**DEVIATION REQUEST
AND DECISION FORM IN
ASSOCIATION WITH A
REQUEST FOR A PUD
MODIFICATION FROM
THE ECM**

Project Name : Villages at Sterling Ranch
Schedule No.(s) : 52000-00-552
Legal Description : See title sheet of PUD Plan

A deviation from the standards of or in Section **ECM 2.5.2.C.2** of the Engineering Criteria Manual (ECM) is requested.

Accessible Curb Ramps – 4-way intersections require pedestrian ramps on all corners

6. ECM 2.5.2.C.2

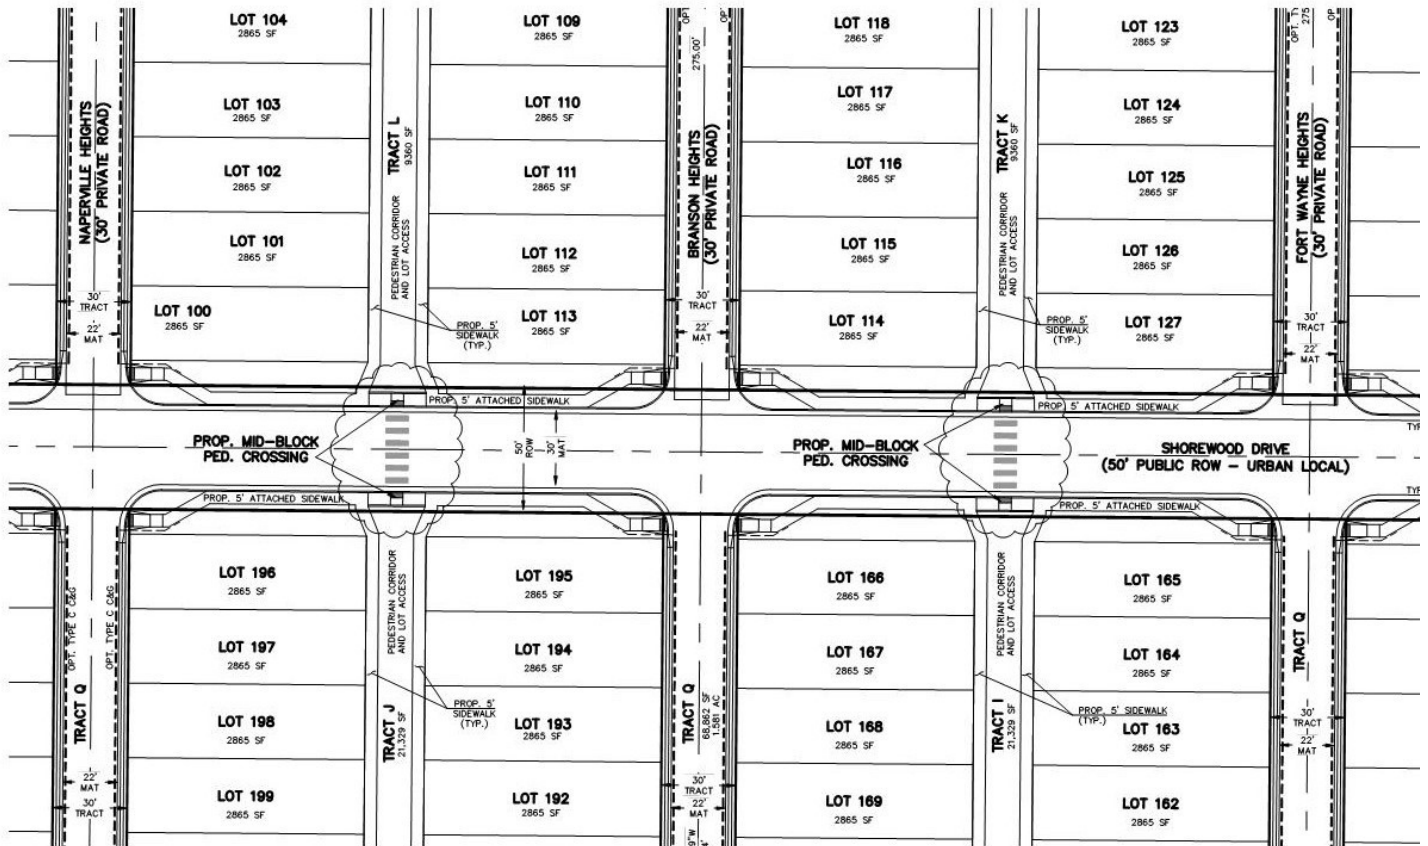
Please provide documentation from other design resources or jurisdictions within the area showing that pedestrian ramps are not required to be at all 4 corners.
